Application Reference: 2024/0883

Site Address: 2 Milne Street, Barugh Green, Barnsley, S75 1LB

This application seeks full planning permission for the erection of first floor side extension to dwelling (Amended Plans and Elevations)

PLANS & ELEVATIONS

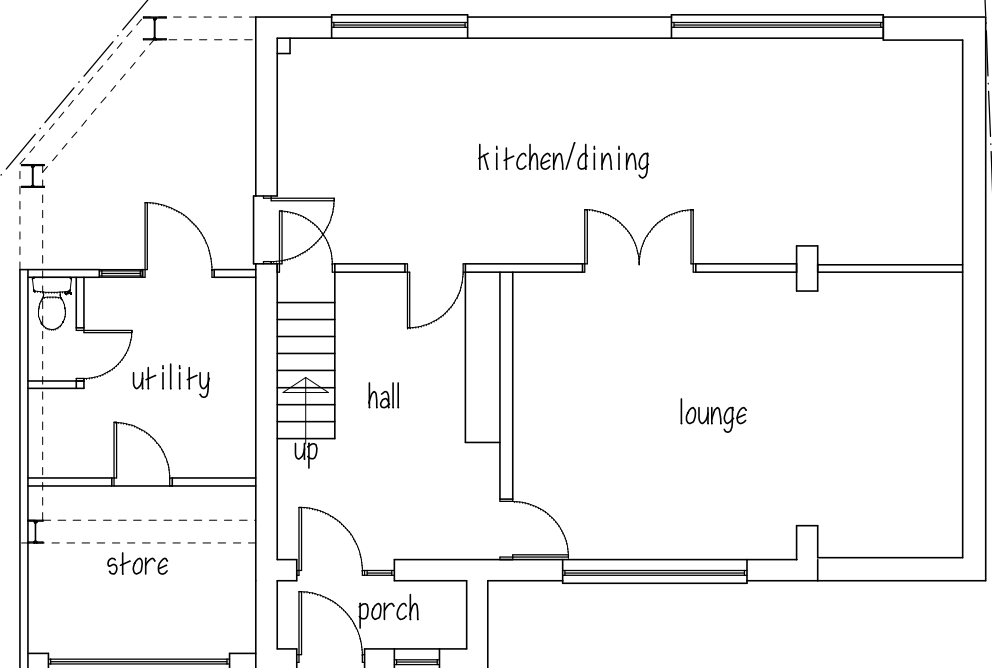
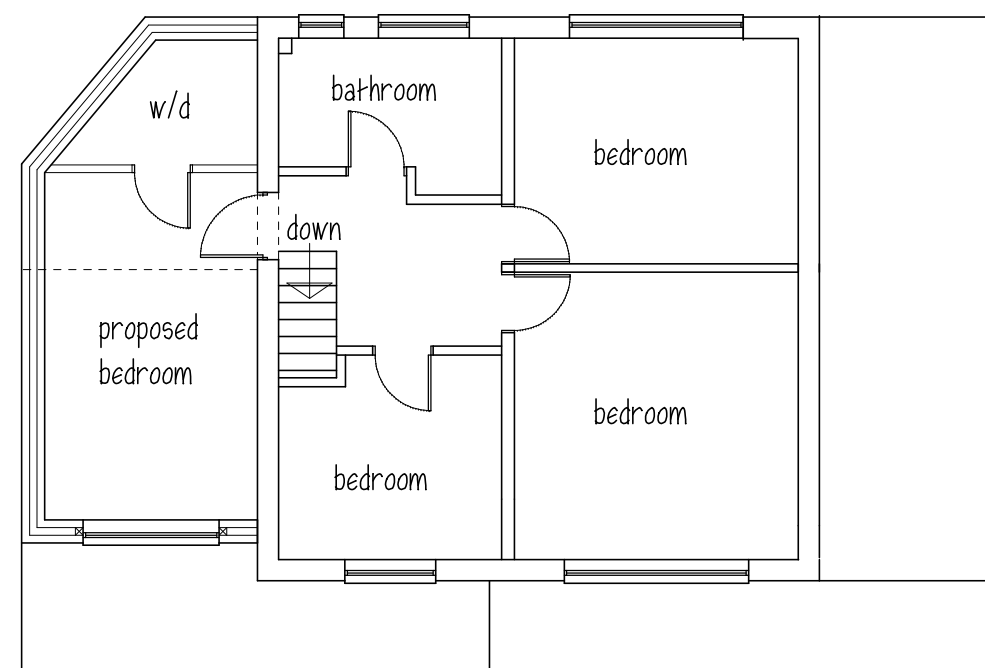
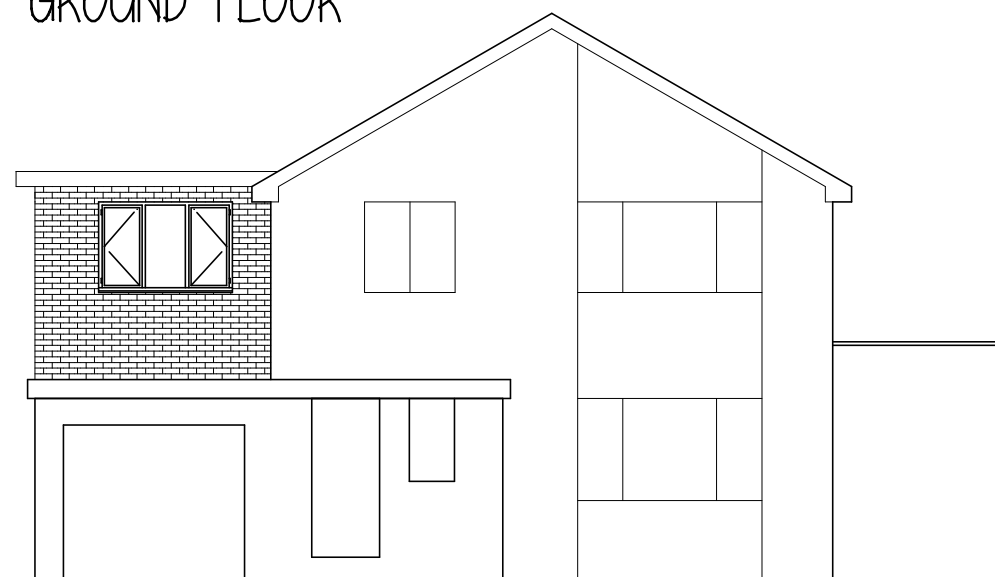
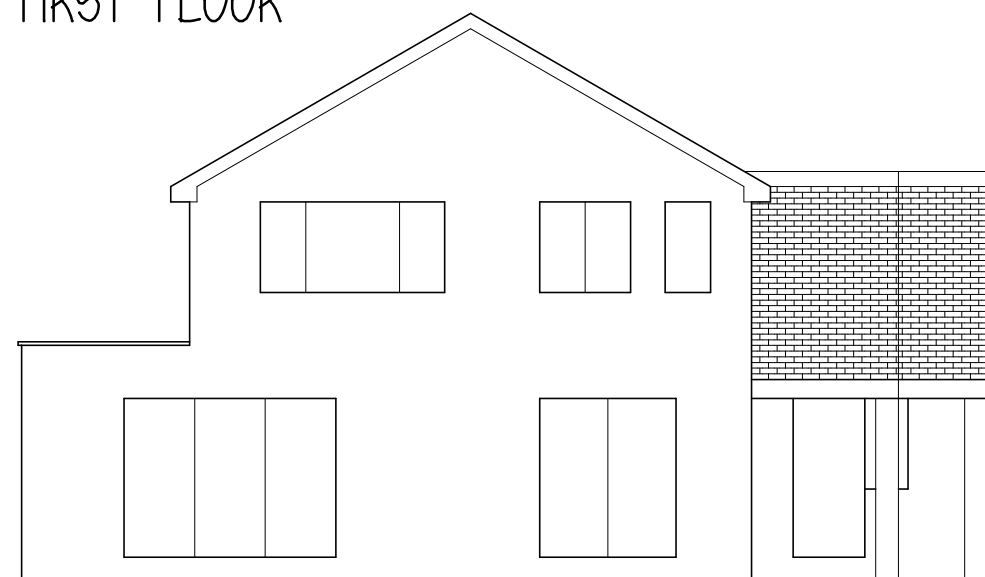
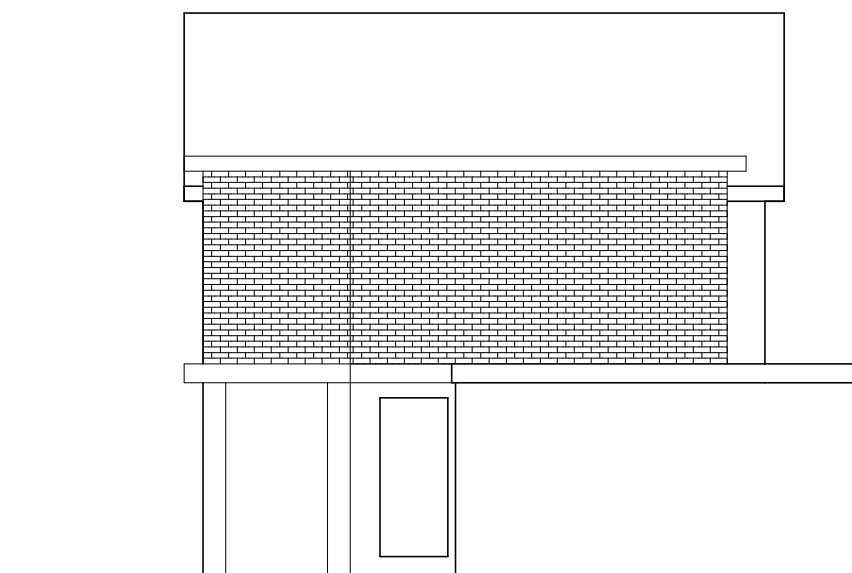
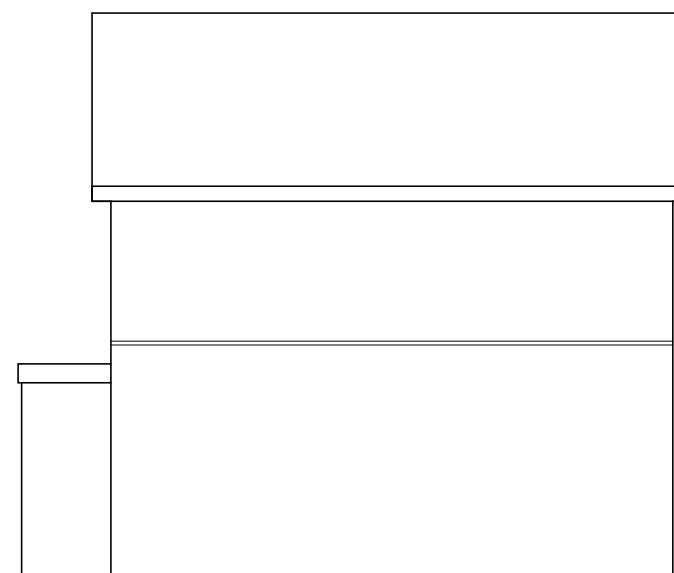
- Alteration of proposed flat roof to hipped roof.

PLANS & ELEVATIONS

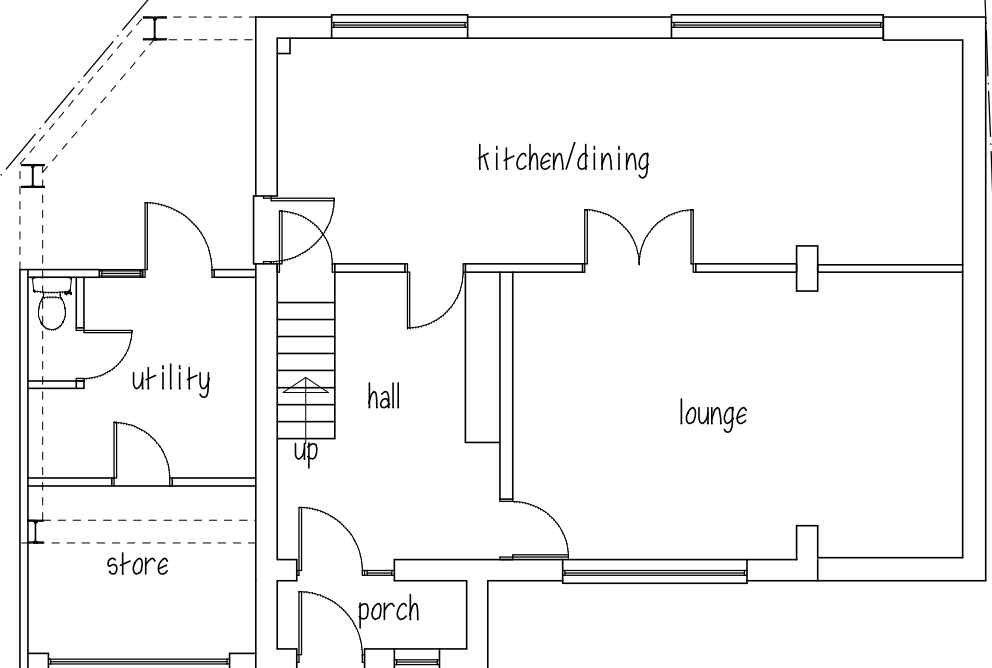
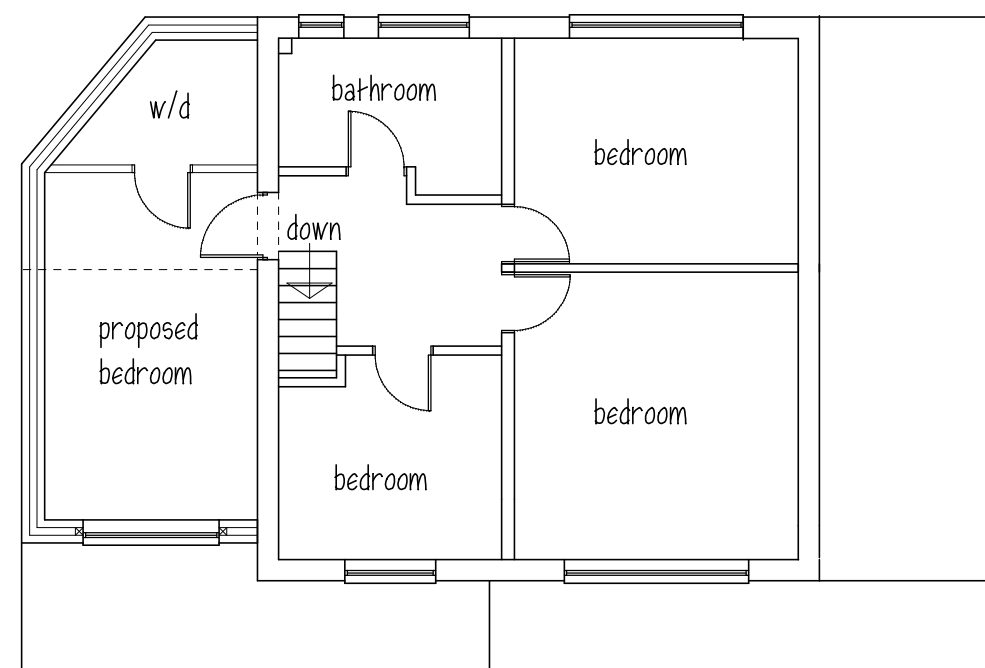
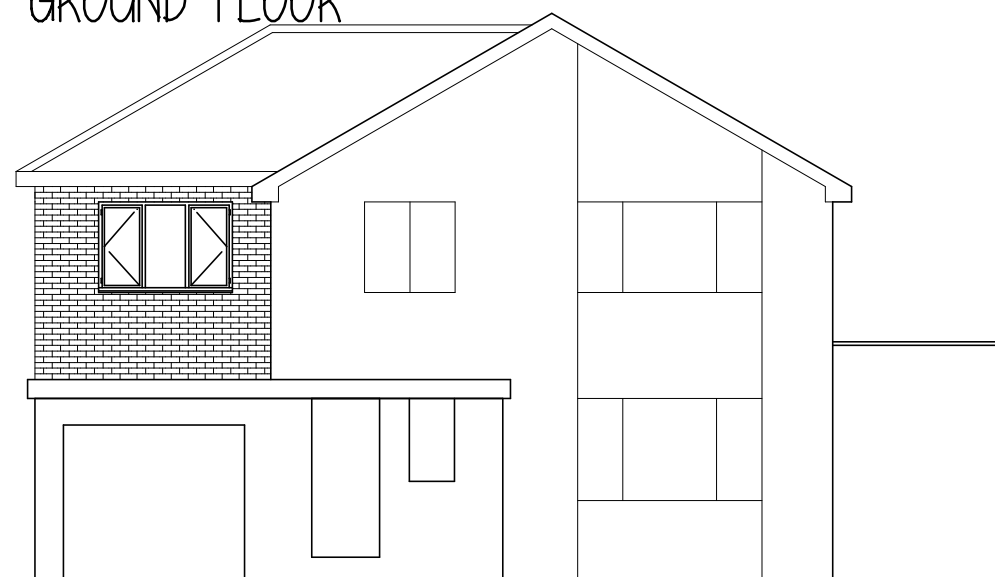
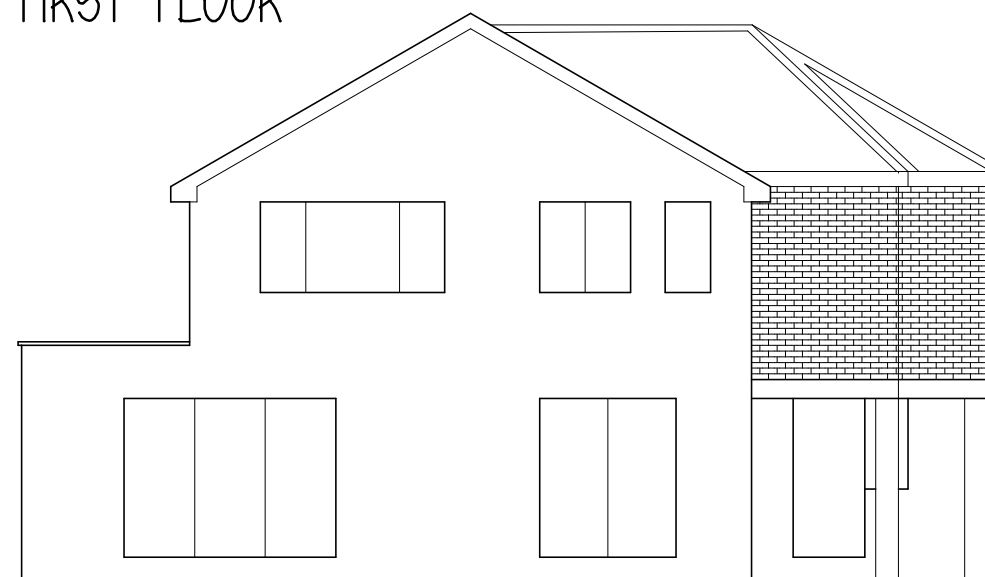
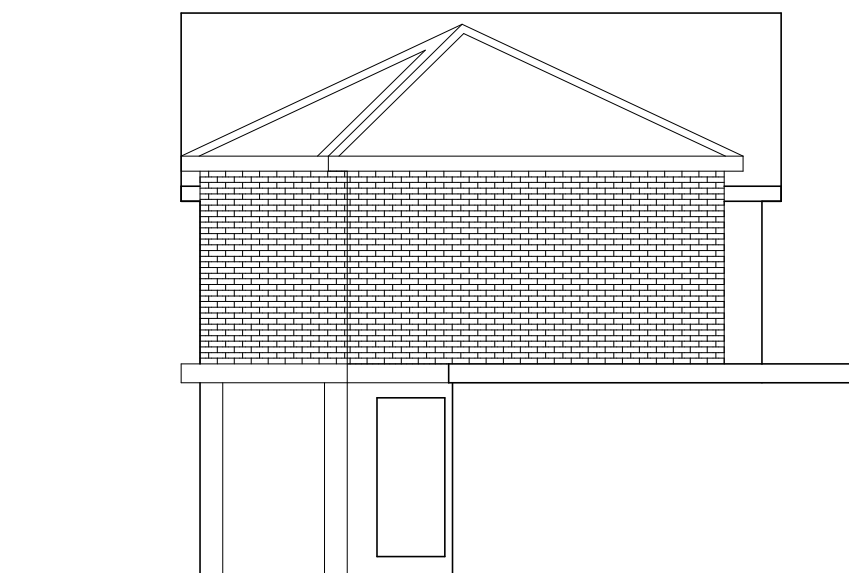
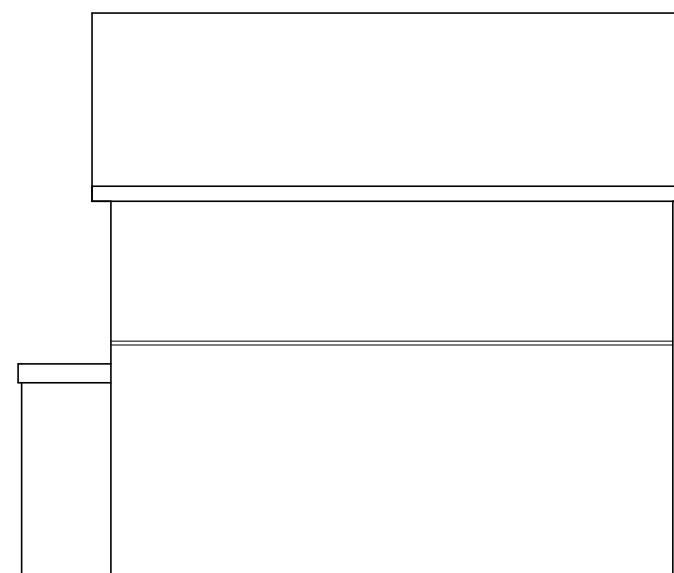
The proposed extension would project approximately 3.1 metres in line with the existing single storey extension. A maximum sideward projection of 5 metres would be permitted under the House extensions and Other Domestic Alterations SPD. The sideways projection is therefore considered compliant. The proposal is set back from the front elevation of the original dwelling by approximately 0.5 metres and set back from the single storey storeroom by approximately 1.7 metres. This assists in ensuring the proposal remain subordinate to the existing dwelling, reducing the impact on the street scene.

A window is detailed to the front elevation symmetrically to the extension and with matching fenestration to the existing dwelling. Matching materials have been detailed ensuring the property remains in keeping with the character of the street scene.

No windows are detailed to the side or rear elevations, preventing any opportunity for overlooking into neighbouring amenity space to the rear and east. The window to the front elevation provide no greater opportunity for overlooking than the existing front windows to the dwelling. The proposed front window is not therefore considered to pose any detriment to neighbouring loss of privacy.

The extension is proposed to the northwest of neighbouring 4 Milne Street. Given the proposal is to the northwest there is little opportunity for loss of sunlight to 4 Milne Street to the southeast. The proposal details a hipped roof form. This allows for the highest part of the proposal nearest to the boundary to be at eaves height, approximately 5.2 metres.
